Date 05 July 2021

RE: 6/2020/3222/MAJ – Former Volkswagen Van Centre, Comet Way, Hatfield, AL10 9TF

Charlotte Kemp
SuDS & Watercourses Team Leader
Hertfordshire County Council

Stantec Drawing 47179/4001/002 Surface Water Drainage Strategy

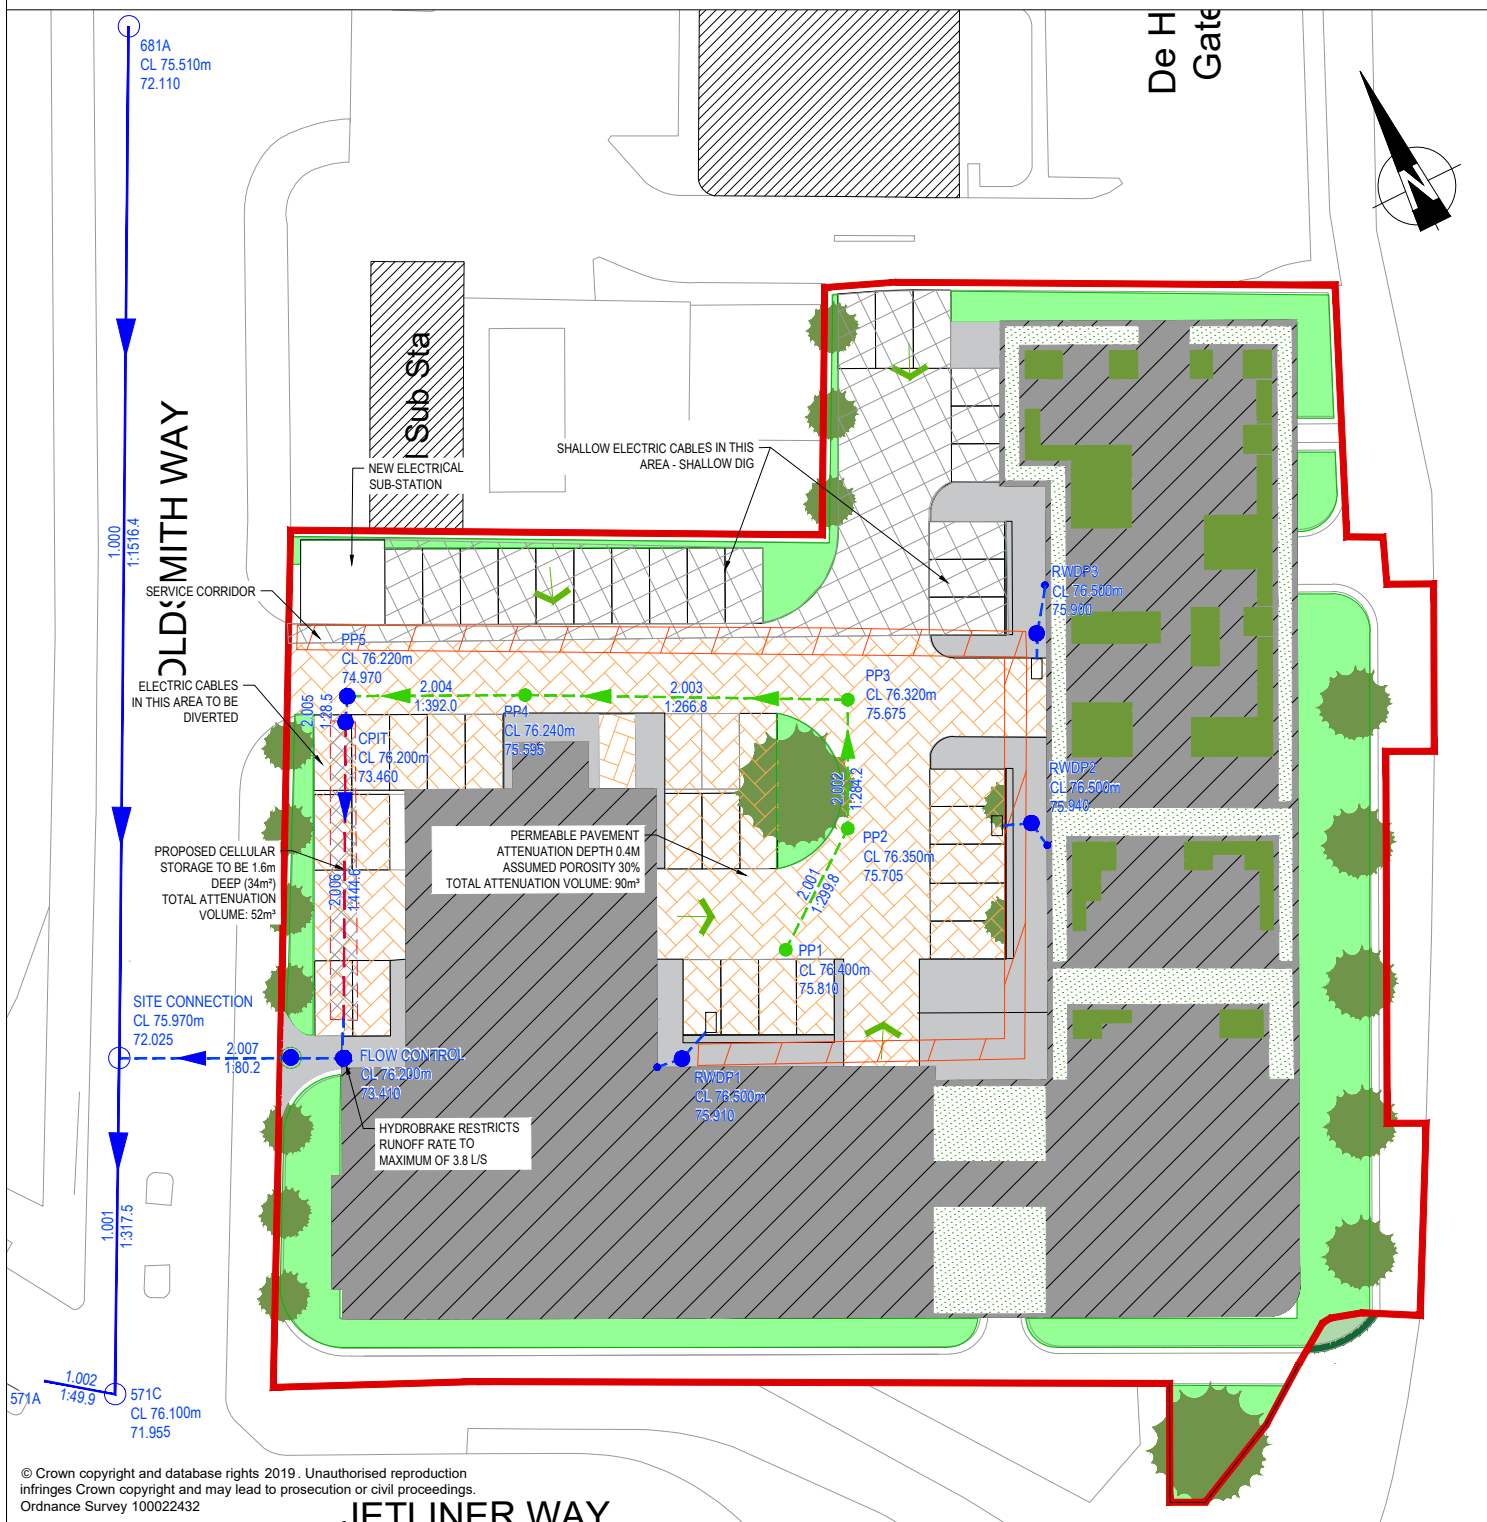
2. We note that some of car parking areas, located outside of the building footprint, will be provided with permeable paving with sub-base. However, there are some parking spaces where these structures cannot be provided. Therefore, the applicant should clarify how surface water from those areas will be captured and treated prior to reaching the piped network.

Moreover, it should be clarified and identify on a plan how the rest of undercroft parking will be drained, as no information has been provided.

As the LLFA, we are assessing surface water drainage within the application's red line boundary. Therefore, the applicant should clarify how they intend to drain new proposed footpaths around the building.

On the submitted drainage plan the proposed depth of the cellular storage does not match with the cross section drawing included. We would advise this should be consistent and the layout plan should be updated. In addition, depth of permeable paving sub-base structure should be also clarified.

Any changes based on our comments above should be supported by an updated report, modelling and an updated drainage layout. The applicant should ensure the drainage strategy report matches with the provided FRA.
